Lean To 10'x40'

DISAPPROVED
Plan Review

EPC Planning & Community
Development Department

AG2013

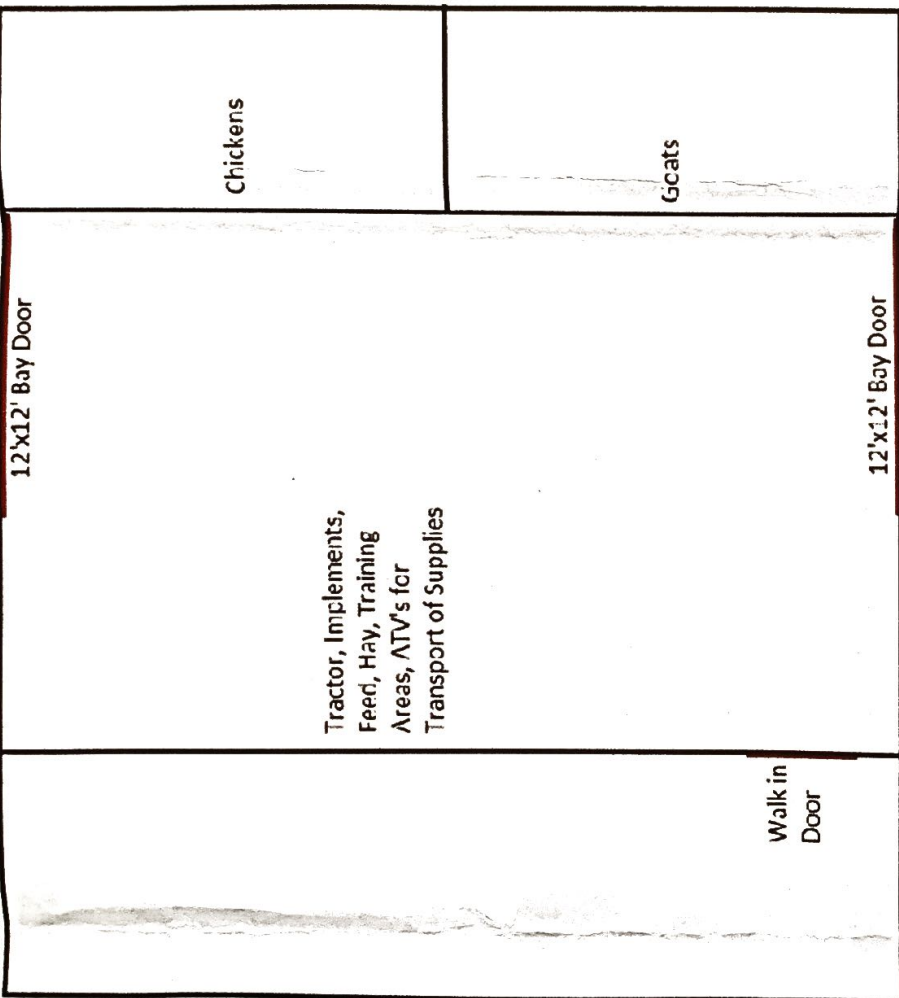
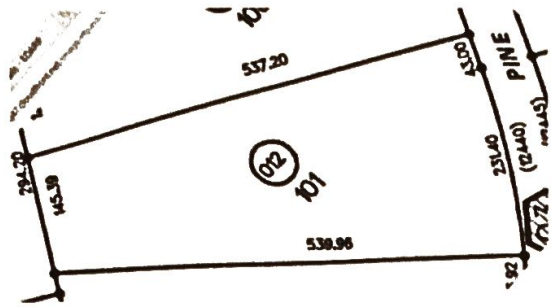
INCOMPLETE SITE PLAN

SIDE SETBACK MUST BE 15'
